Addendum No. 1

RE: Contract # C204924

1 SECTION OF NC-53, 10 SECTIONS OF SECONDARY ROADS, AND 11
SECTIONS OF NON-SYSTEM ROADS

March 19, 2024 Letting

CONTRACT STANDARDS AND DEVELOPMENT UNIT			
Office 919-707-6950		FAX 919-250-4119	
SHOULDER WEDGE DETAILS			
ORIGINAL BY:	T.SPELL	DATE:	7-19-11
MODIFIED BY:		DATE:	2/2/16
CHECKED BY:		DATE:	
FILE SPEC.:	s:\usr\details\stand\shoulderwedgedetail.dgn

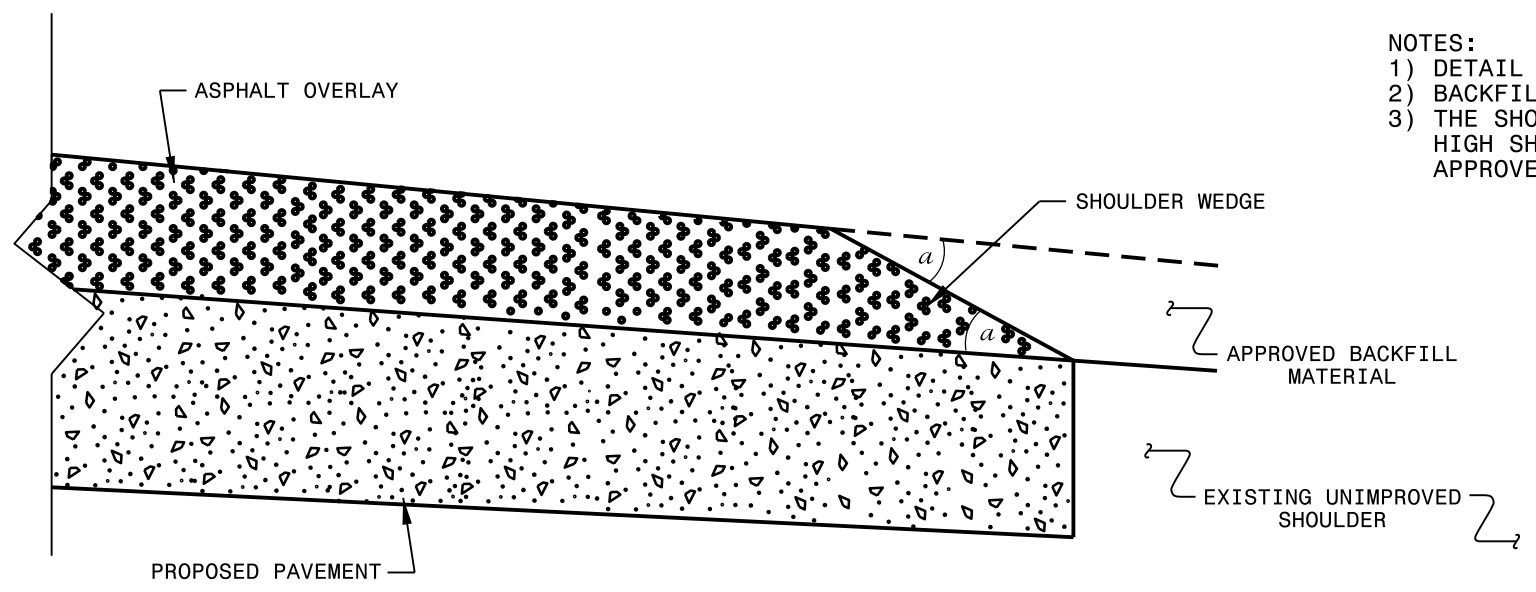
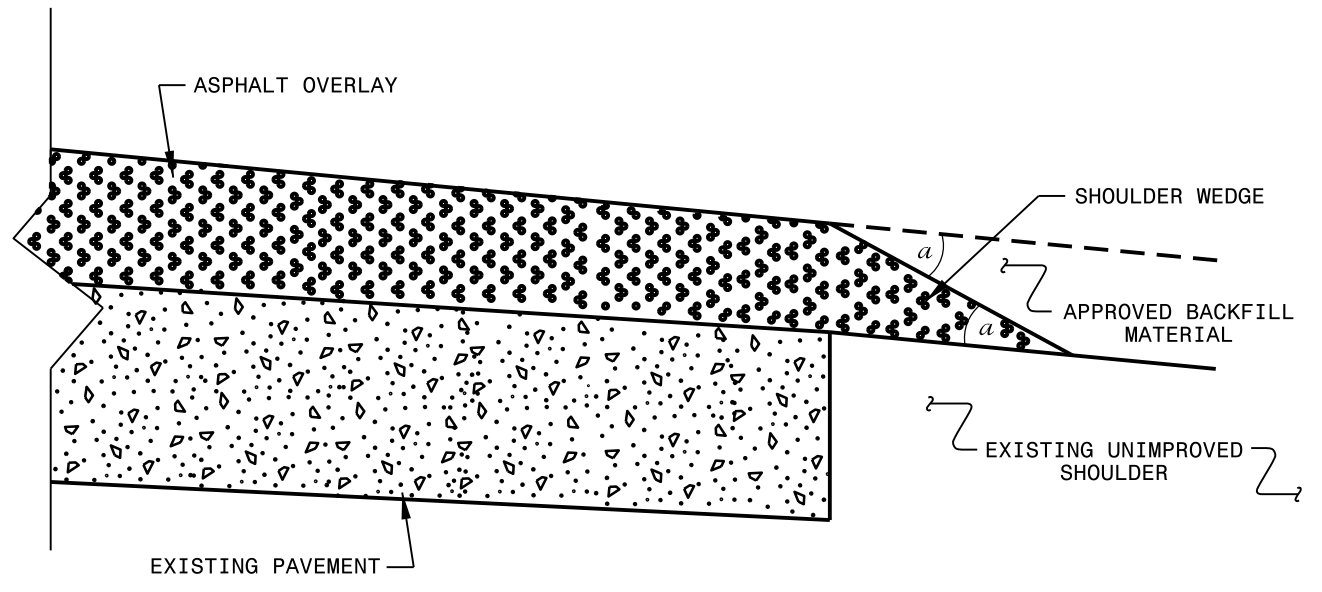
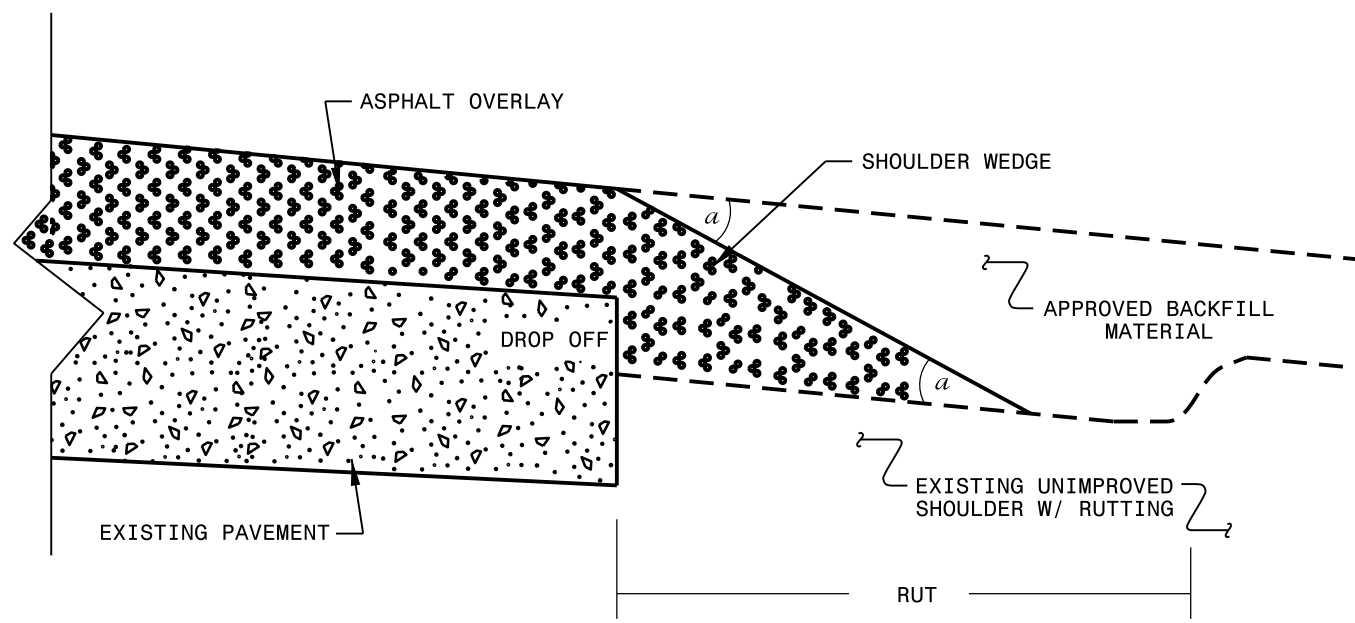
Page No.	Revision
Proposal Cover	Note added that reads "Includes Addendum No. 1 Dated 03-05-2024".
TC-1 thru TC-11	The Project Unit Special Provision entitled TEMPORARY TRAFFIC CONTROL (TTC) has been revised. The last sentence in "Paving Operations" - Section 4 "Shoulder Drop-Off Requirements" that reads "The material, equipment and labor associated with this operation will be paid as Shoulder Borrow in accordance with Section 560 – Shoulder Construction of the <i>Standard Specifications</i> " has been replaced with "The material, equipment and labor associated with this operation will be paid as Aggregate Shoulder Borrow or Borrow Excavation in accordance with the Shoulder Reconstruction Per Shoulder Mile special provision found elsewhere in the contract."

Backfill the edge of pavement drop-off with suitable compacted material, as approved by the Engineer. The material, equipment and labor associated with this operation will be paid as *Aggregate Shoulder Borrow* or *Borrow Excavation* in accordance with the *Shoulder Reconstruction Per Shoulder Mile* special provision found elsewhere in the contract.
